**From:** Steve English [REDACTED]  
**Sent:** 31 August 2017 [REDACTED]  
**To:** Paul Cann; Anita Gardner  
**Cc:** Hugh Parker; david hawtin; Garry Davies  
**Subject:** RE: 40923 - Audi Worthing - Amended Drainage Strategy A/77/17/DOC

Planning Ref: A/77/17/DOC

SCALE WHEN PLOTTED AT A2		DRAWING STATUS	
1:200 1:25		FOR APPROVAL	
DRAWN	CHECKED	DATE	DRAWING NUMBER
MW	SJE	11-04-17	40923/061
			REV
			E

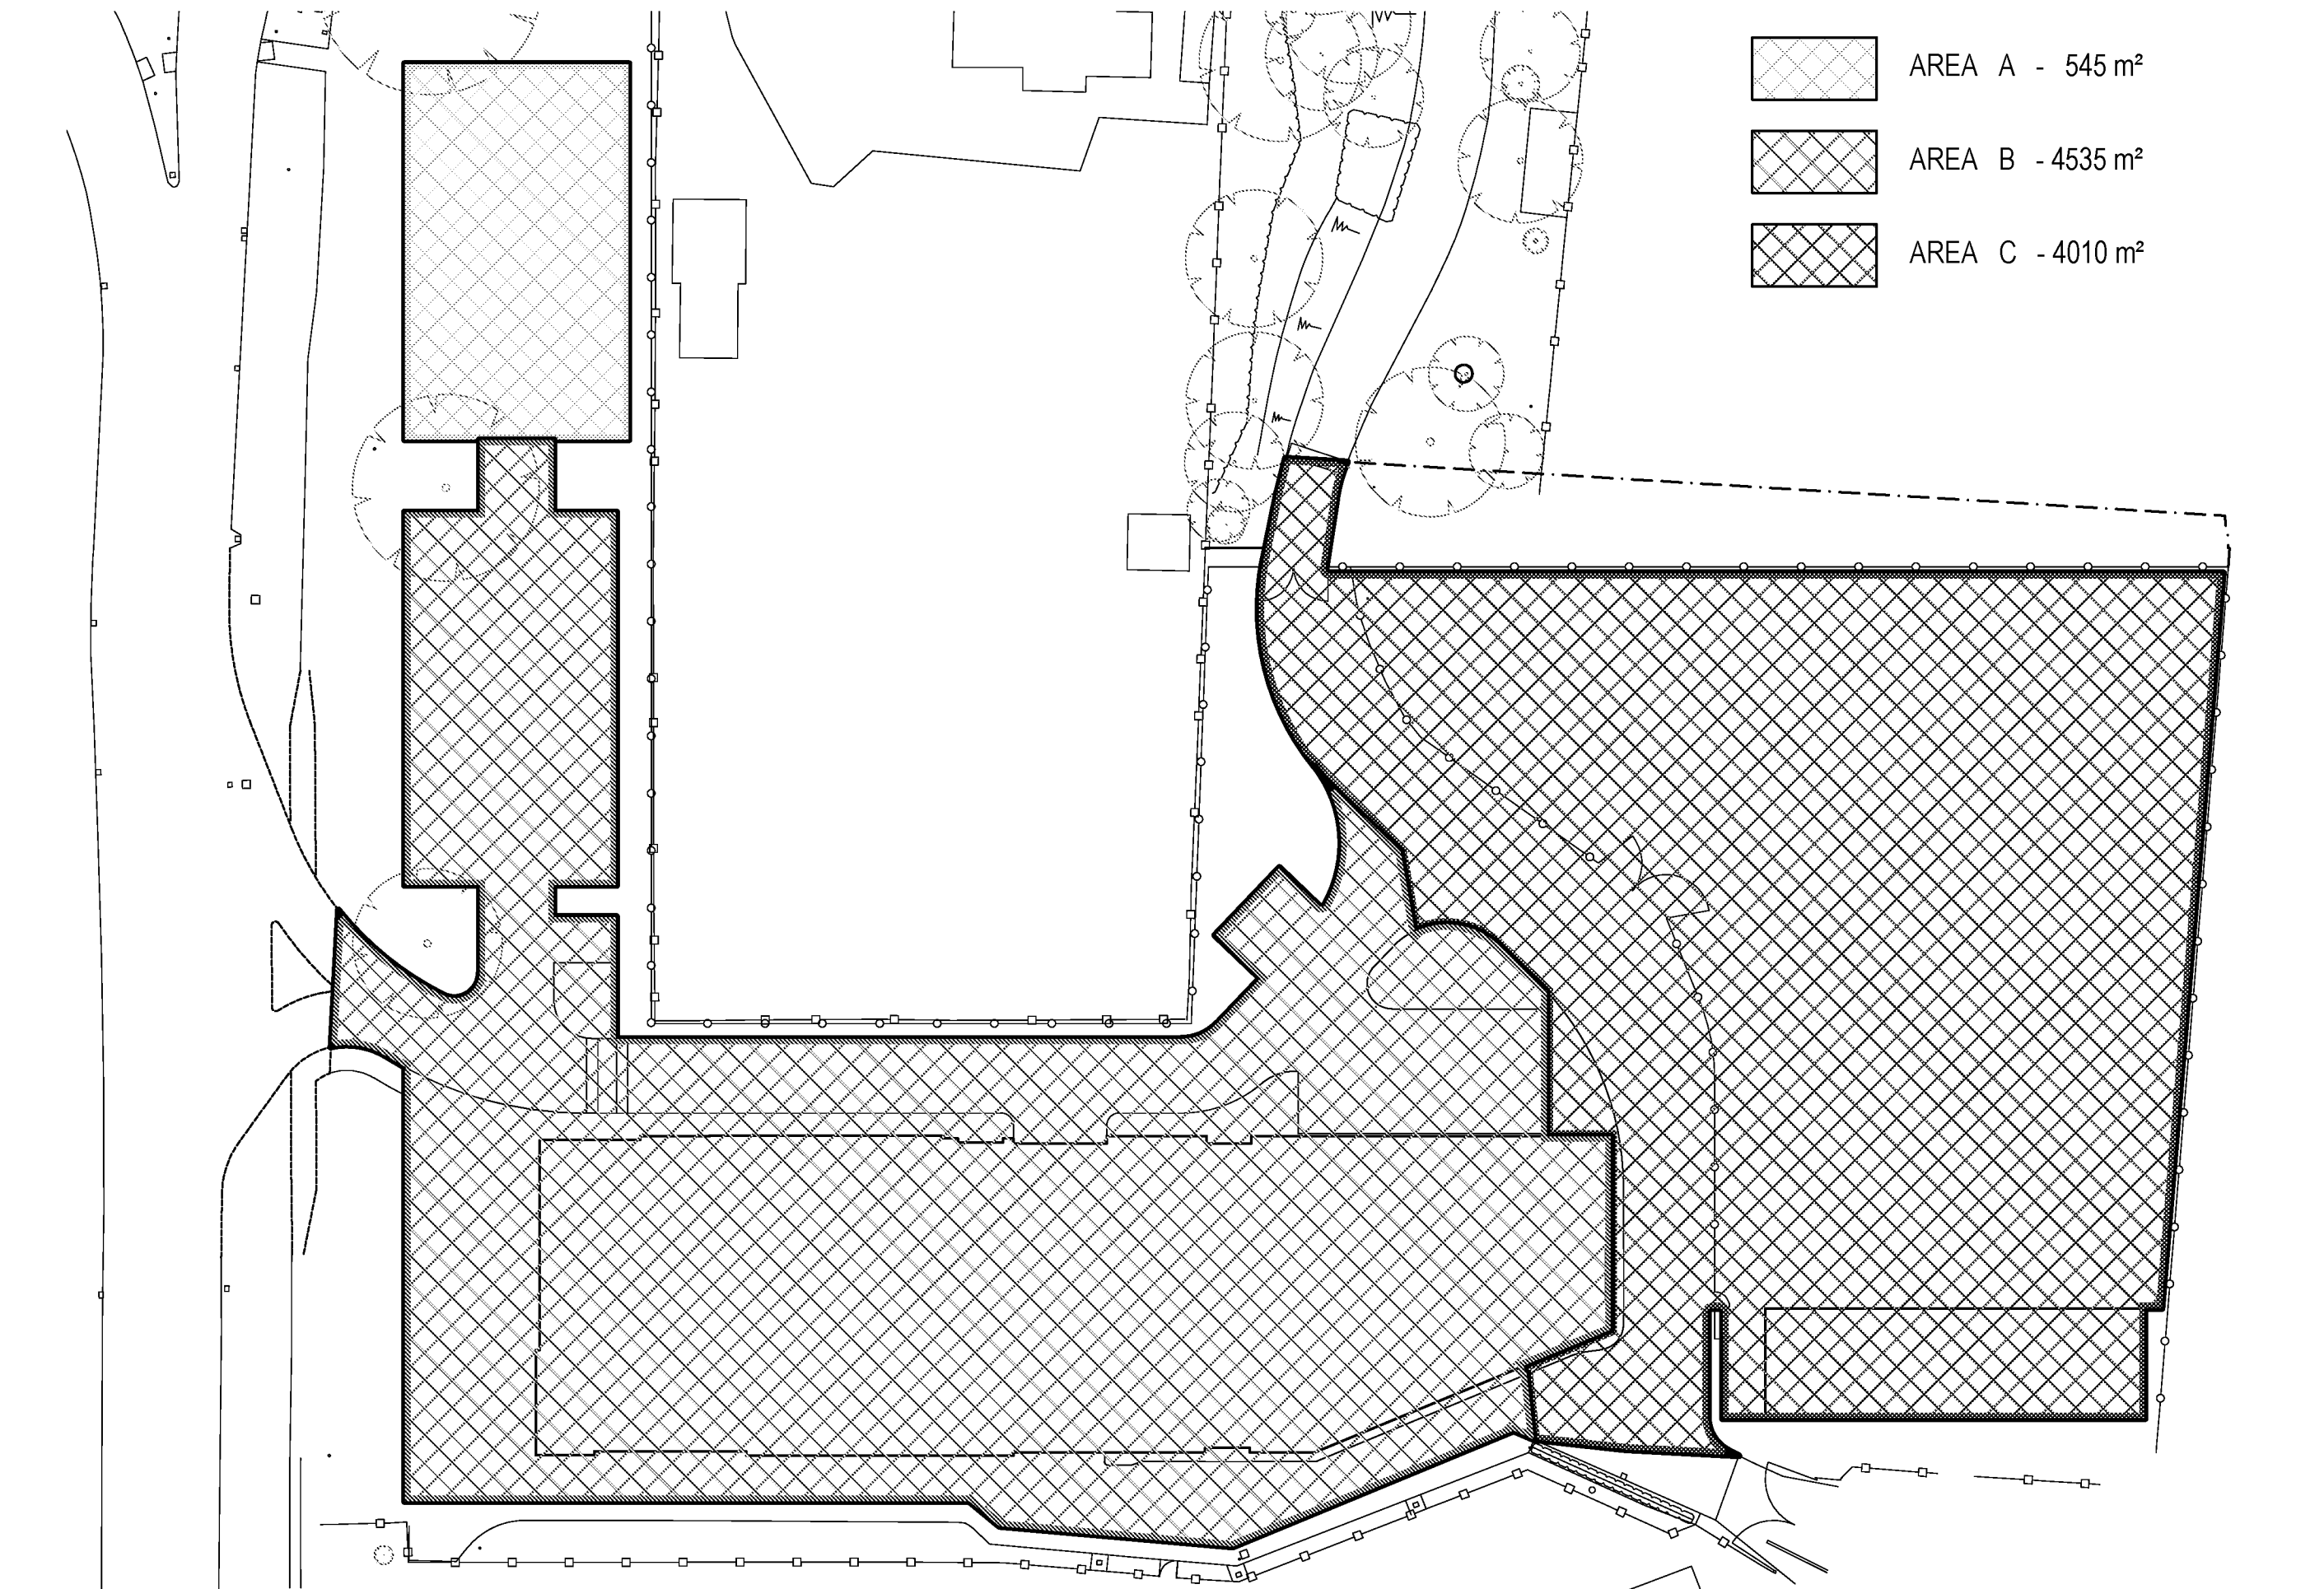
Please can you also update the legacy note on the drawing.

1. Increase overflow pipe diameters to 150mm and specify a class Z bedding on each one.
2. I note the existing surface water pipe that crosses the site and your intention to fully investigate it. Whilst this will fall outside this planning condition (no.4), I would be grateful if you could keep me updated on your findings.

3. Regarding the perforated pipes located above the soakaways, can you specify/confirm how the pipes will be protected from vehicular loadings, due to the lack of cover.
4. Have you discussed the scheme with the Environment Agency in terms of any requirement for oil interceptors, particularly for the larger car park.

Further to the email thread below, please find attached a PDF copy of our amended drawing numbered 40923/061G. This drawing has been revised as requested to remove the legacy note and increase the size of the overflow pipes.

We have specified 150 dia. pipes (40kNm) located in "Main Traffic Roads", so a minimum cover of 0.6m is appropriate.

There is adequate cover (from a structural perspective) for the perforated pipes within the soakaway trenches, as they have a minimum of 600mm cover. In addition, the trenches will be lined and covered with terram to prevent fines entering the stone voids.
